Current Zoning: N1-A (Neighborhood 1)  
Proposed Zoning: UR-2(CD) (Urban Residential, Conditional)

Approximately 19.75 acres located on the north side of Choate Circle between Legree Lane and Freshwell Road.

The petition proposes to allow redevelopment of a site in the Steele Creek community with a multifamily residential community containing 350 dwelling units and accessory uses.

**RZ.01**

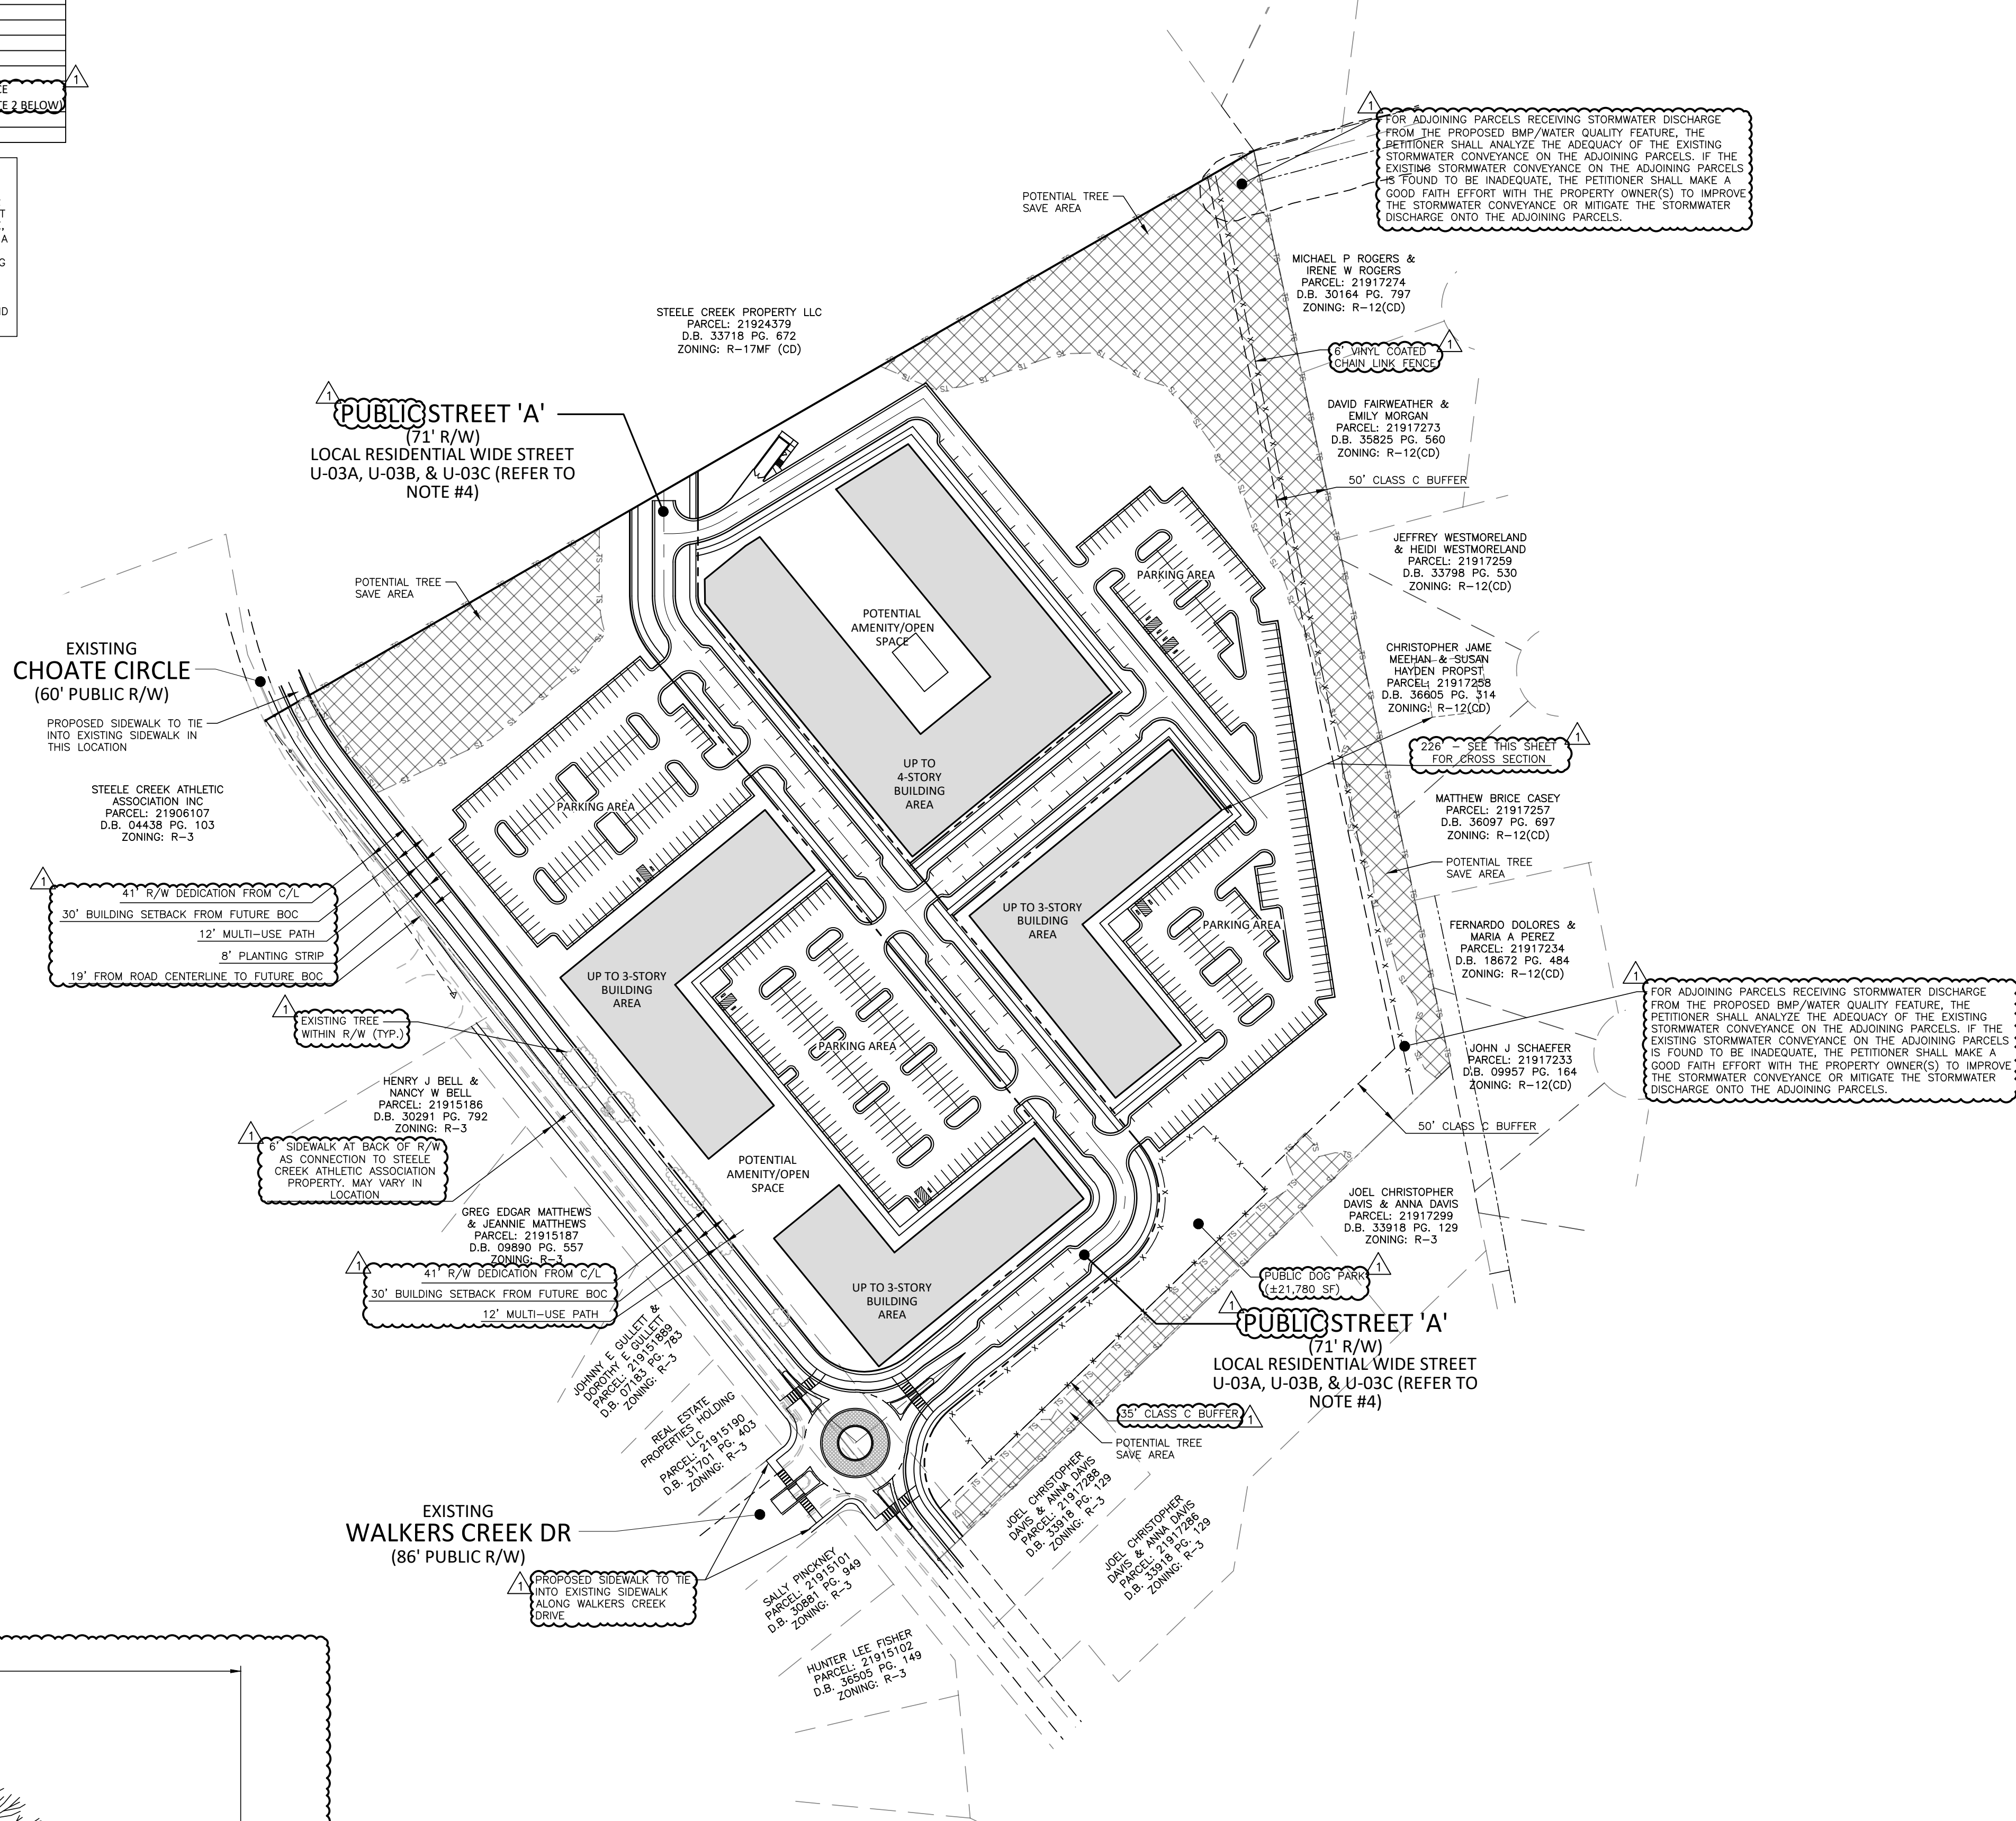
1. ~~Revise the site plan and conditional notes to convert the proposed private streets to public streets.~~

2. ~~Provide tree survey identifying all trees of eight inch DBH or greater and all planted trees of two inch caliper or greater and six feet in height that grow partially or wholly within the city right of way.~~

3. ~~Delete the word "building" from setback note on site plan.~~ ADDRESSED

4. ~~Delete the second sentence of note 4.c stating "The proposed Class C buffers may be made of existing vegetation and new vegetation".~~ ADDRESSED

ADDRESSED

ADDRESSED
